# CITY OF ALBUQUERQUE

**Re: StarBucks**  
**8721 Washington NE**  
**Traffic Circulation Layout**  
Architect's Stamp 10-15-2020 (C17-D128)

Based upon the information provided in your submittal received 10-23-2020, the above referenced plan cannot be approved for Building Permit until the following comments are addressed:

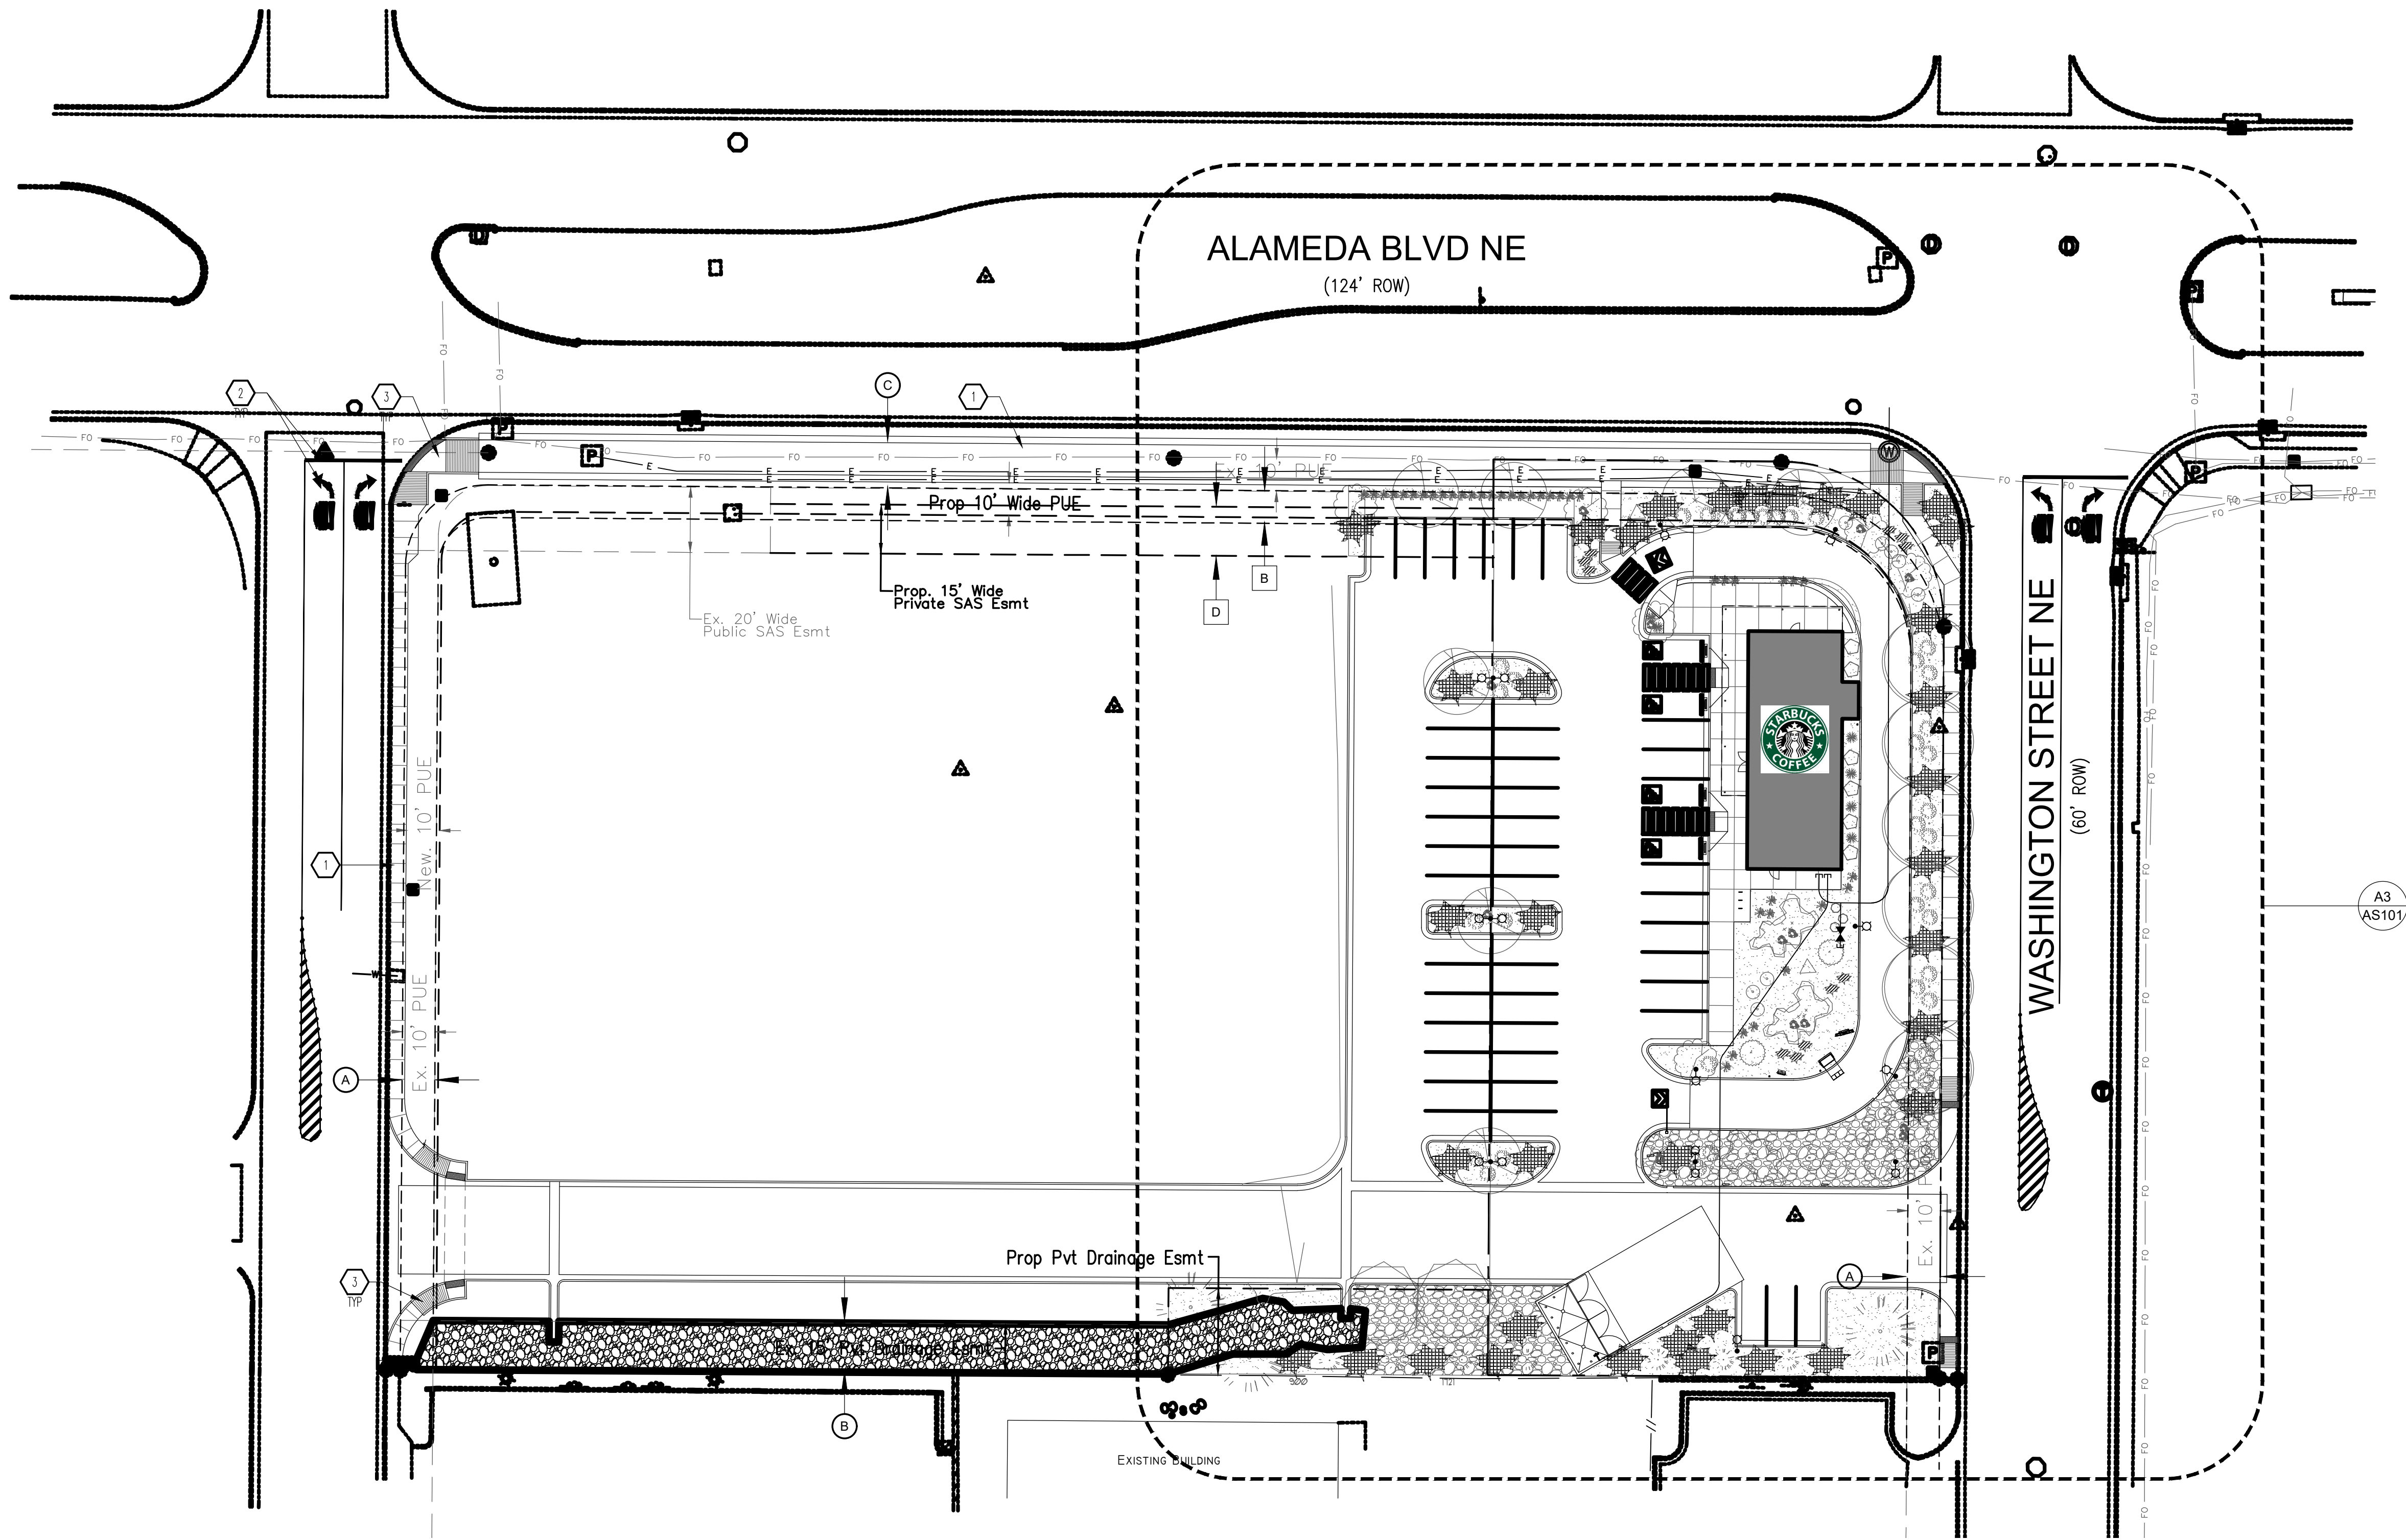
1. The traffic circulation layout must be stamped, signed, and dated by an engineer or architect licensed in the state of New Mexico.
2. **TIS Status: TIS approval prior to TCL(building permit) approval.** See the Traffic Impact Study (TIS) thresholds. In general, a minimum combination of 100 vehicles entering and exiting in the peak hour warrants a Traffic Impact Study. Visit with Traffic Engineer for determination, and fill out a TIS Form that states whether one is warranted. In some cases, a trip generation may be requested for determination.
